Subject: RE: Planning Consultation on: AL/59/22/DOC

Engineers Comments Regarding Surface Water Drainage

Site Address: Field Place Nyton Road Aldingbourne PO20 3UA

Description of Works: Approval of details reserved by condition imposed under AL/116/21/HH relating to condition 5-surface water drainage.

LONG SECTION THROUGH HIGH CAPACITY SOAKAWAY

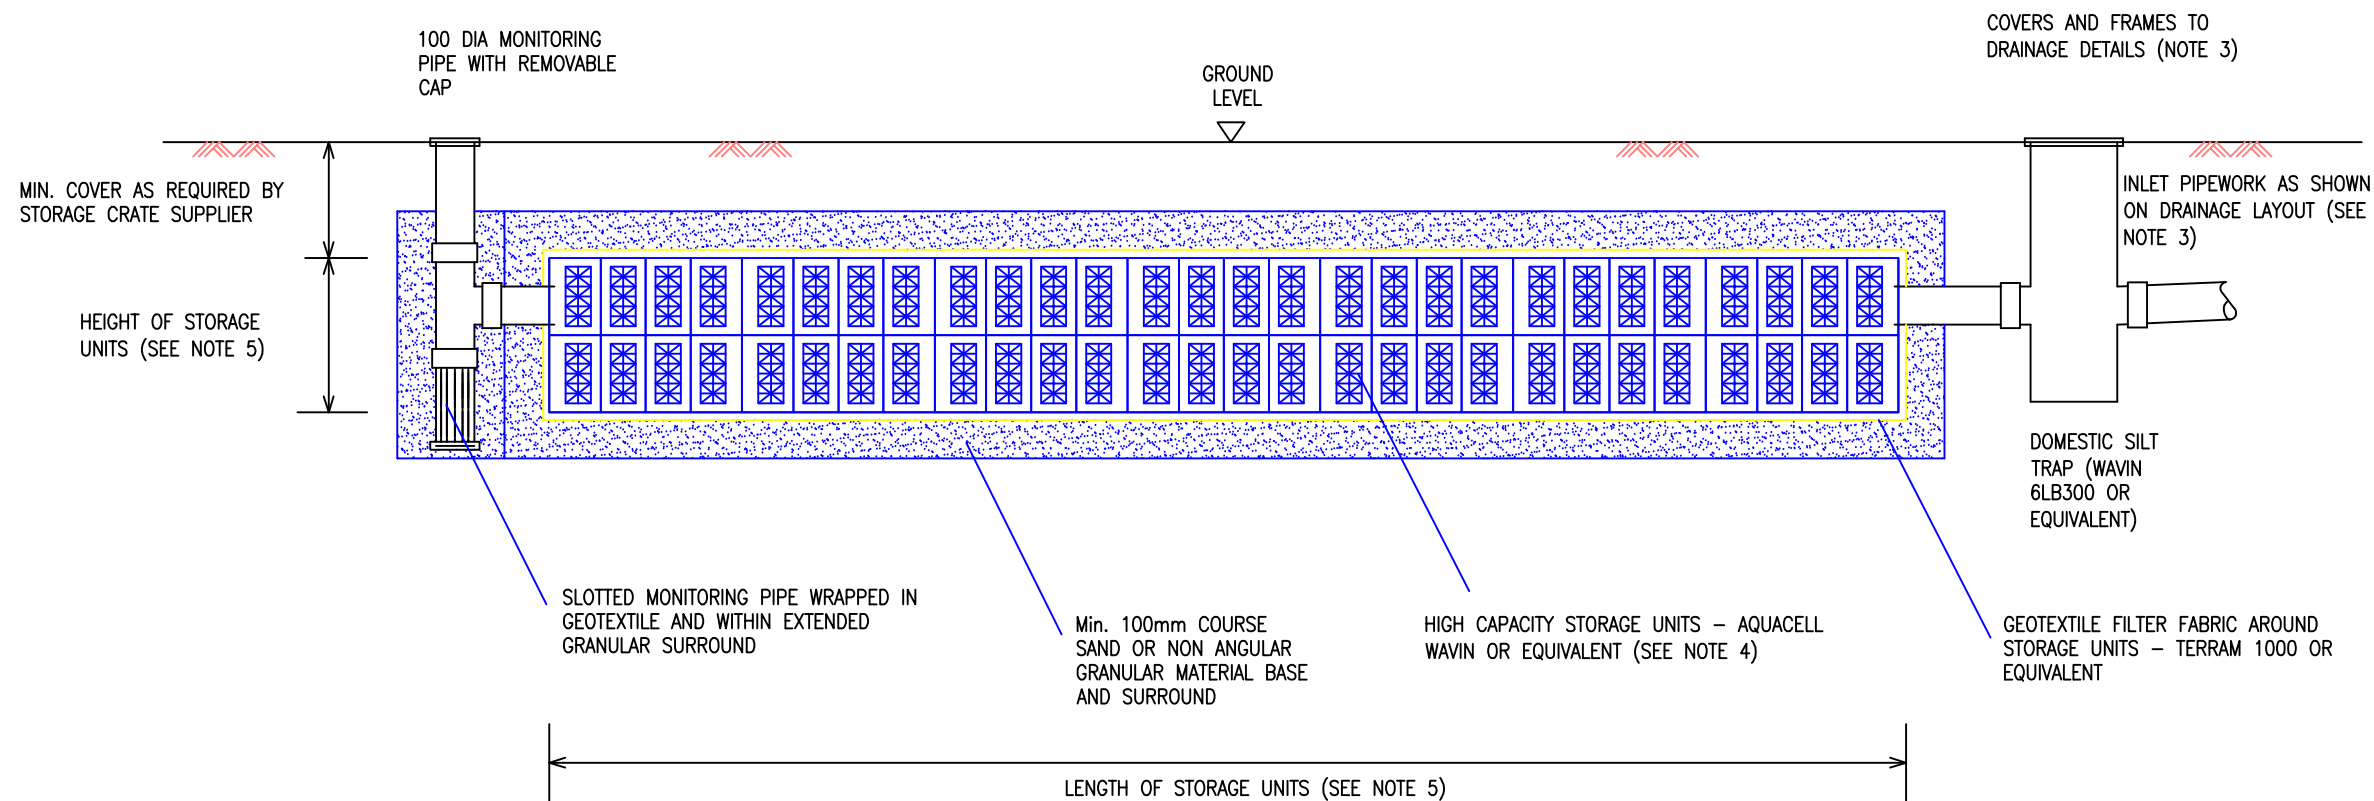
7. Please specify and provide details for the soakaway crates to be used. Ensure cover depth is appropriate for the specified crates.
8. We require further detail for the construction detail drawings.

- a. Please specify invert level of incoming pipe on construction detail drawing.
 - b. Please detail the sump depth of the silt trap – to be minimum of 300mm. Please also include bed and surround.

- c. Please include construction detail for pipe bed and surround, it is expected that class z is used where crown of pipe is less than 1200mm in vehicular areas or less than 900mm under other areas.

Proposed groundworks plan

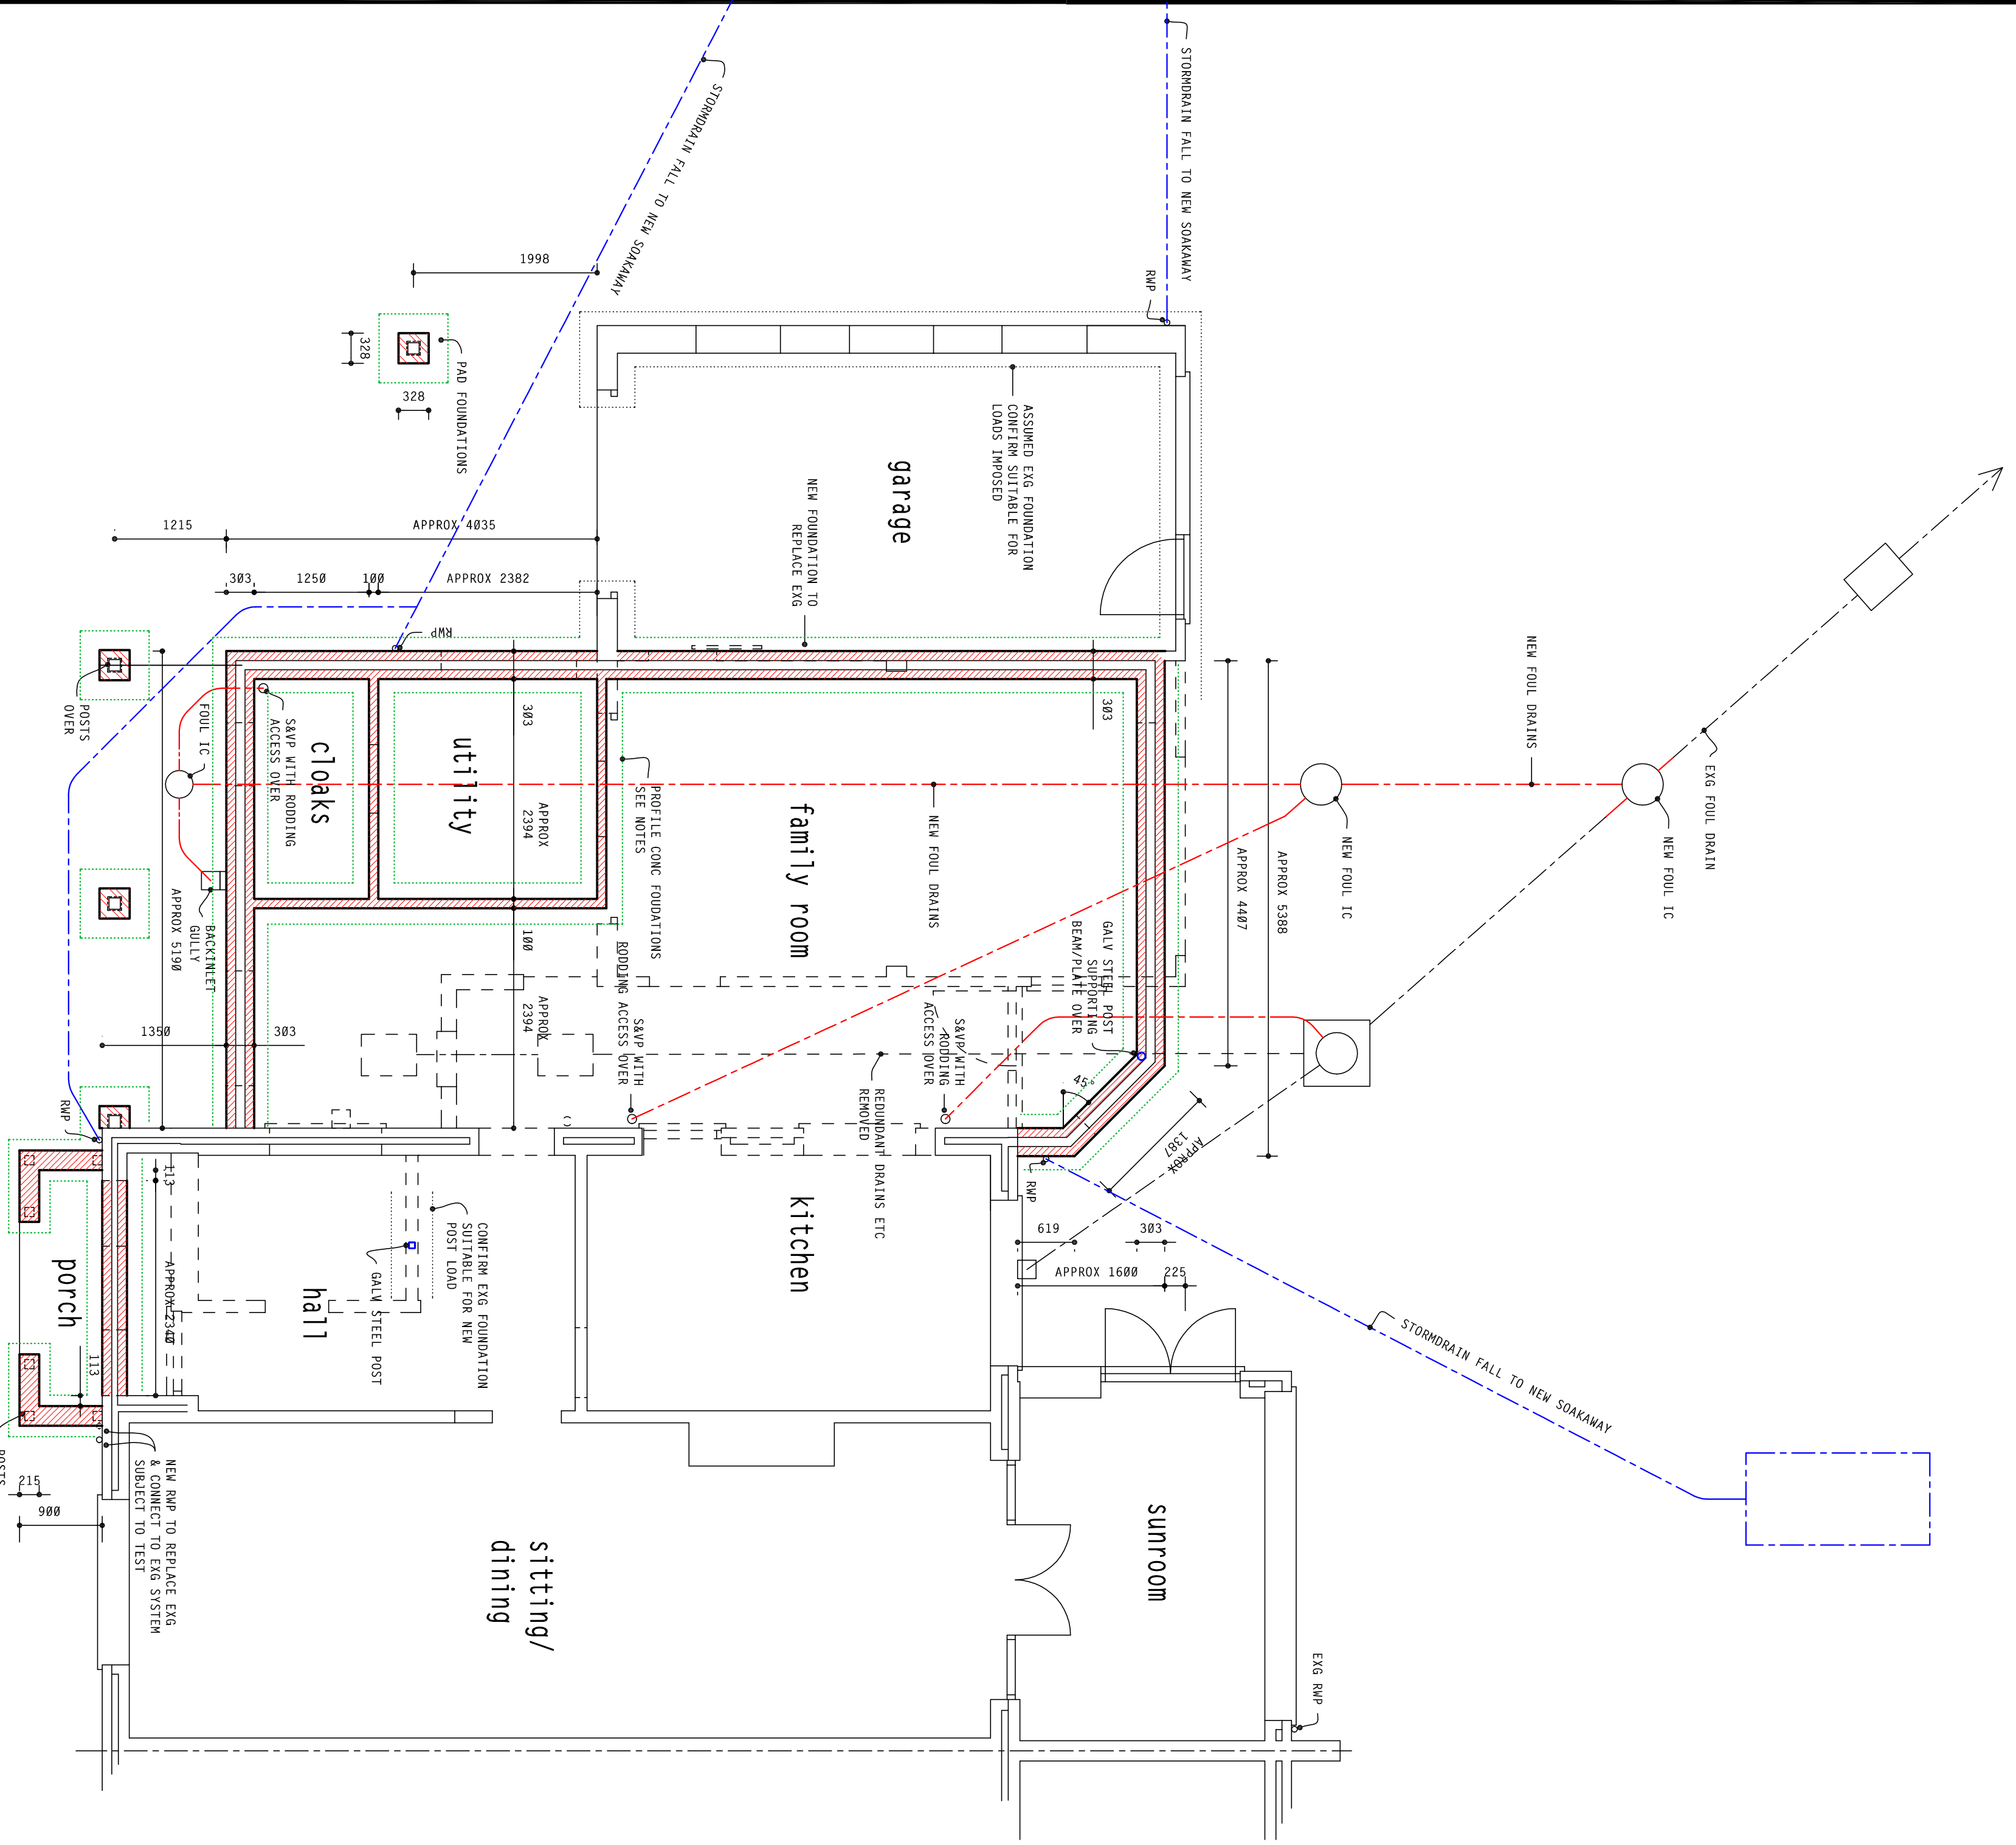
6. The drainage layout requires further detail. Please see guidance note k on our [drainage checklist](#) for a detailed list of our requirements for drainage layout drawings.
